## City of Albuquerque Stormwater Construction Site Inspection Report

ESC File No.	M09E025A	Project Name:	Sage Ranch Subdivision
NPDES Id. No.	NMR1003YW & NMR1004GM	Location:	9600 Sage Ranch Ct. NW
2/28/2022	Owner/Developer	Owner/Builder	
Operator	Vuelo, LLC	Westway Homes	
Contact name & title	Gordon Rowe	Mike Feetz	
e-mail	<a href="mailto:growe@roelawfirmPC.com">growe@roelawfirmPC.com</a>	<a href="mailto:mike@thewestway.com">mike@thewestway.com</a>	
Contact Phone #	301-9431	304-8473	
COA Inspector	Doug Hughes	Start/End Time:	2pm
Construction Phase:	House Construction		
Type of Inspection:	<input type="checkbox"/> Regular	<input type="checkbox"/> Storm Event	<input type="checkbox"/> Past Storm Event >0.25"
		<input type="checkbox"/> 311/Complaint	<input checked="" type="checkbox"/> Follow Up
Weather at time of inspection?	clear	Temperature: ~	65
Estimated date of last storm 0.25" or greater	1/1/2022

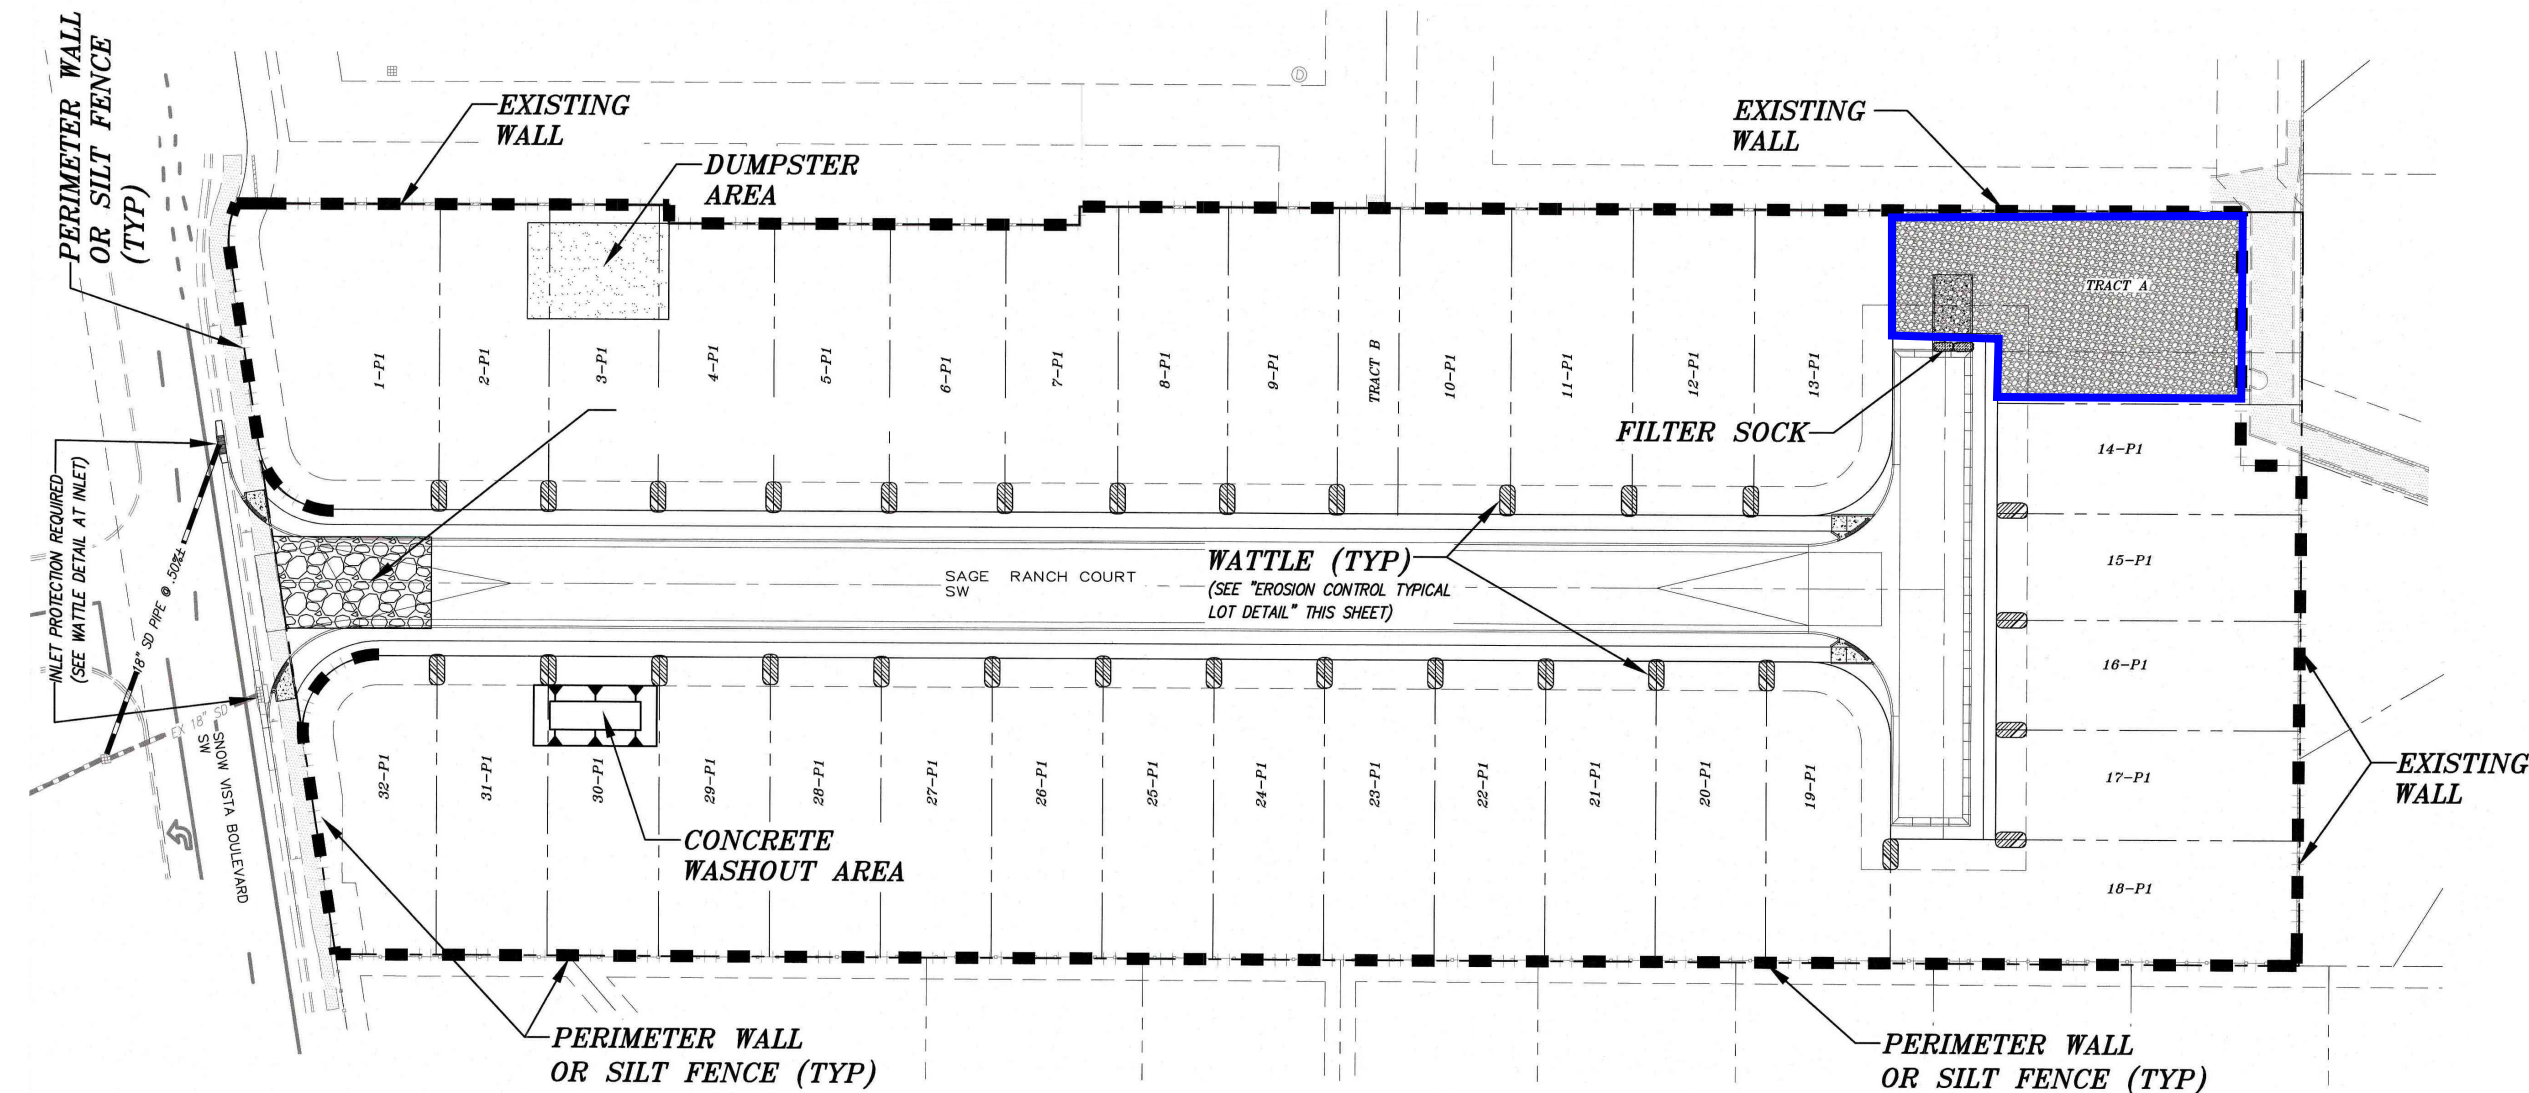
Notes:	
The pond and infrastructure is nearly complete but house construction has't started yet. Landscaping needed between pond and road, riprap missing at bottom of pond rundown.
